From: Michael Eastham
Sent: 09 September 2017 17:53
To: Planning.Responses
Subject: FW: WA/44/17/OUT - Land East of Tye Lane, Walberton

From: Bowie, David [REDACTED]
Sent: 08 September 2017 16:57
To: Michael Eastham
Cc: 'Stephen Gee'; 'Tim Wall'; Bown, Kevin; Franklin, Richard
Subject: RE: WA/44/17/OUT - Land East of Tye Lane, Walberton

I have just attended a Planning Briefing Panel meeting with the councillors from Arun District Council in advance of the Development Control Committee meeting on 20th September Committee, where I presented the outline planning application (WA/44/17/OUT) – Land East of Tye Lane, Walberton.

T:\Projects\11000 Series Project Numbers\11324\ITB Land North of Walberton\Tech\Acad\I-Transport Drawings\Working Drawings\GA\ITB11324-GA-014 Rev B.dwg

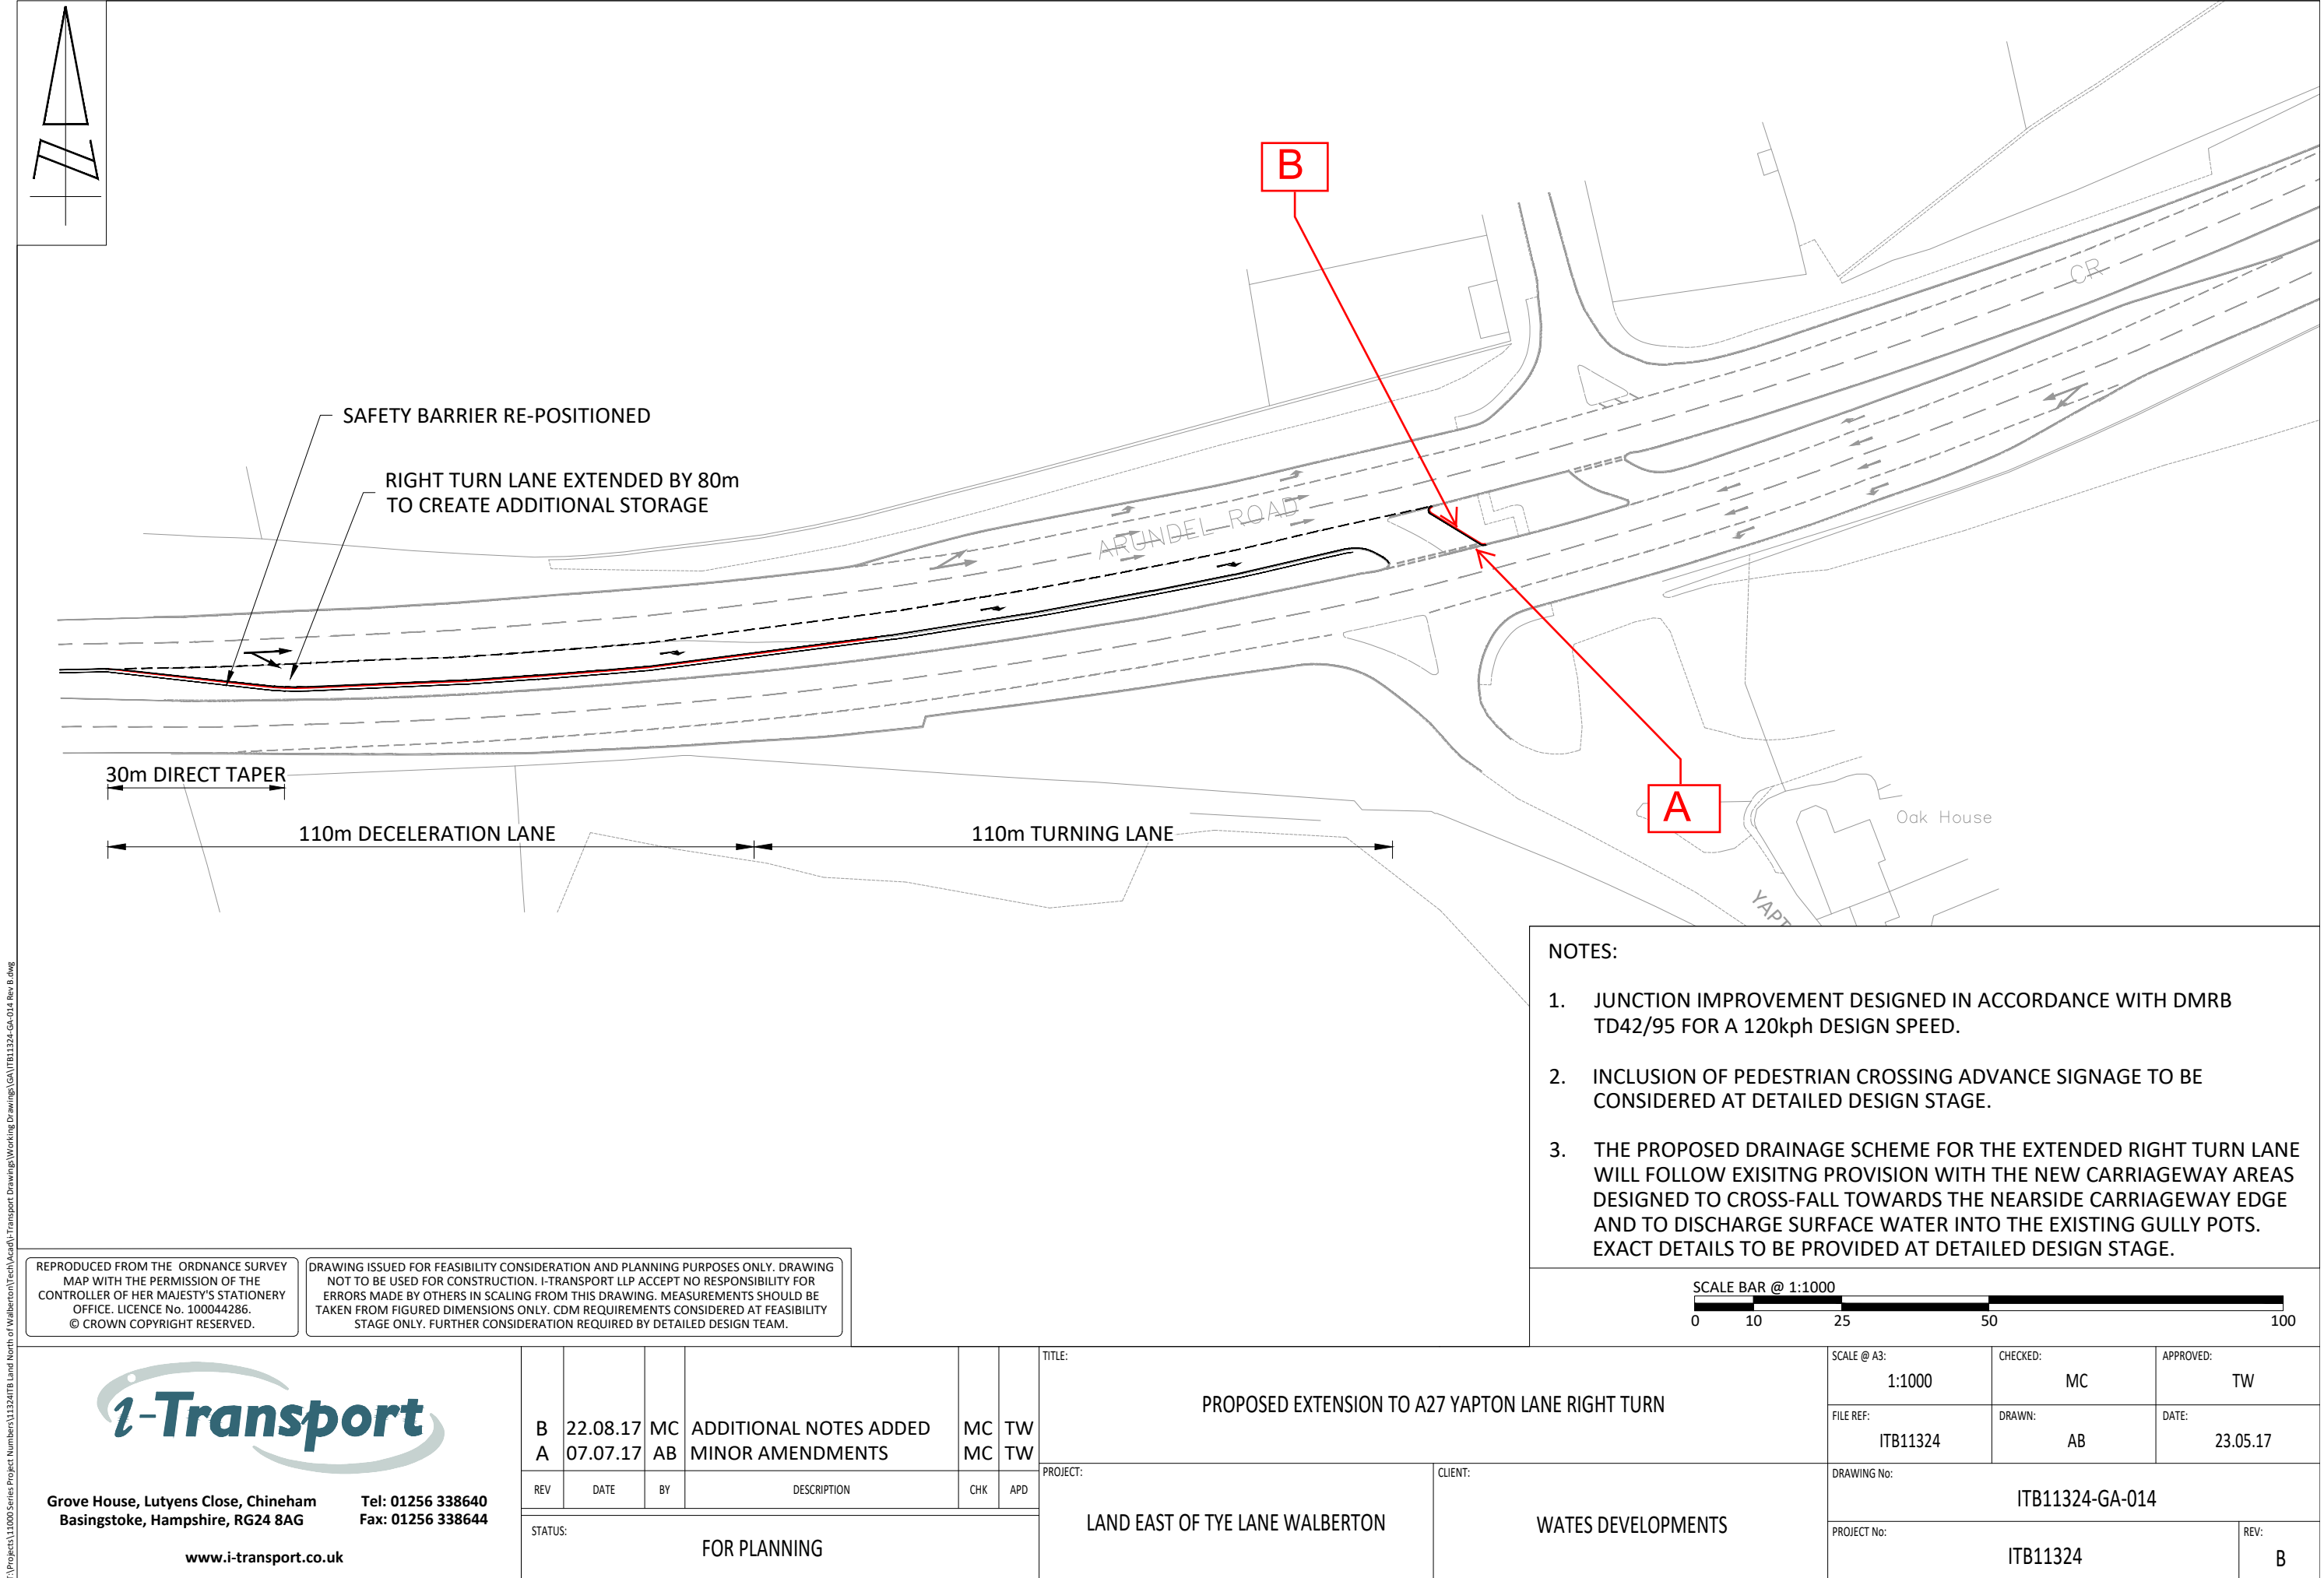
It's only one of the options (Option 5A) which effects the Yapton Lane junction the other two Bypass options under consultation make no changes to the junction. At this point we'd have to say that an agreed Yapton Lane scheme needs to be on the table in the event that our Major Scheme does not provide an improvement at Yapton Lane or that there is no scheme at all (which is possible bearing in mind what happened at Chichester).

Highways England's view would be that if the chosen Bypass scheme made changes at the Yapton Lane junction then the agreed mitigation scheme cost would be put towards that scheme as a contribution. If it didn't go ahead then we'd expect the applicant to deliver it. The wording of our conditions is such that it's an either / or arrangement. Accordingly, I would be advising councillors that the councils s106 agreement simply states that the applicant shall enter into a s278 for the agreed mitigation works on the agreed plan or contributes the equivalent to the Bypass scheme.

Whilst the Bypass proposals have been tested for planned development up to the end of your Local Plan period I am not sure that the 5A junction option has been tested for the amount of extra housing coming through the system outside of the strategic sites. Looking at the form of arrangement I'd say that there is a bit of flexibility, certainly for this site, but if everything currently known is approved we are potentially in the region of 1000 dwellings in and around Yapton / Walberton and I'd be concerned that option 5A might not cope with that level of growth!

During the question and answer session, the chairman of the Development Control Committee questioned the proposed junction improvements at Yapton Lane and the A27 corridor, claiming that the proposed junction improvements are different to those being proposed for the Arundel Bypass.

Councillors are asking if we could see plans of junction improvements at Yapton Lane and the A27 with and without the Arundel Bypass taken place and if the Section 106 Agreement could be drafted with a with and without Arundel Bypass clause.
